**Glendell Continued Operations Project (SSD-9349)  
Request for Additional Information**

The Department is continuing to progress its assessment of the Glendell Continued Operations Project (SSD-9349) and requests that you provide additional information to address the following issues:

Figure 12: Biodiversity Offset Stages

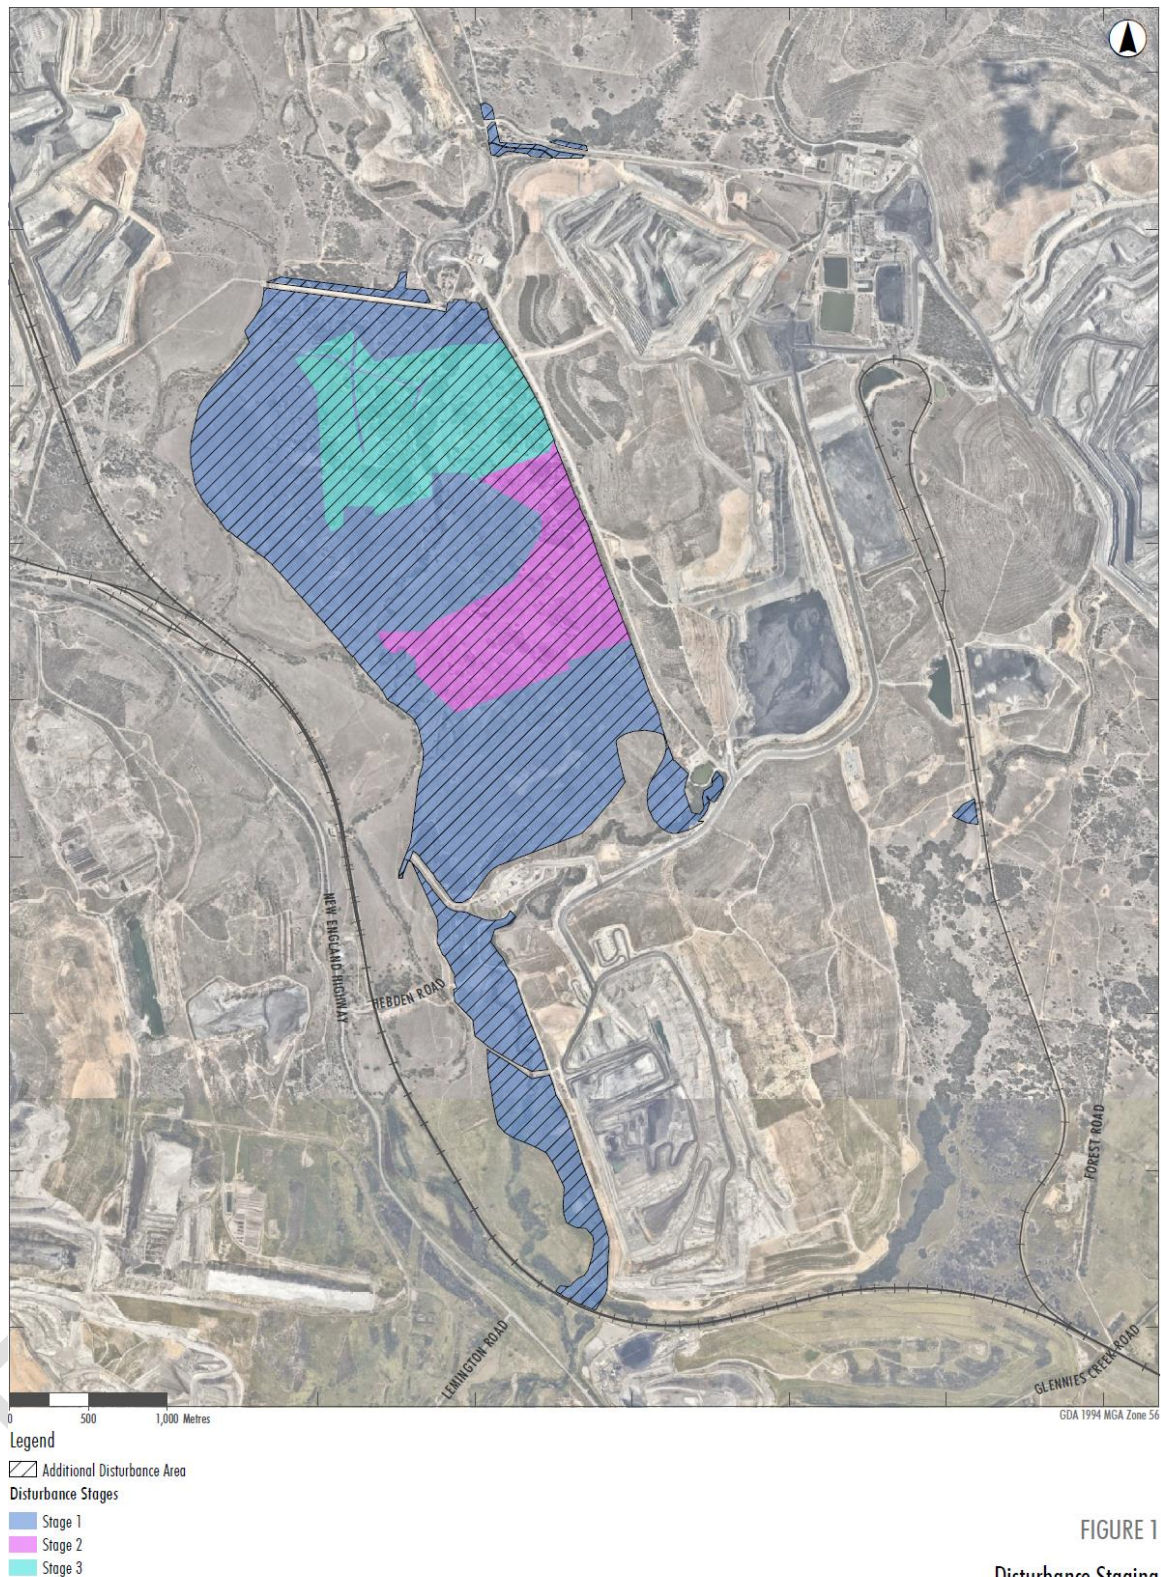
- **Staging of biodiversity offsets** – The Department understands that Glencore is proposing to stage the delivery of biodiversity offsets for the Project. Please provide further information regarding the proposed staging of offsets, including the number and type of biodiversity credits required to be retired for each stage.
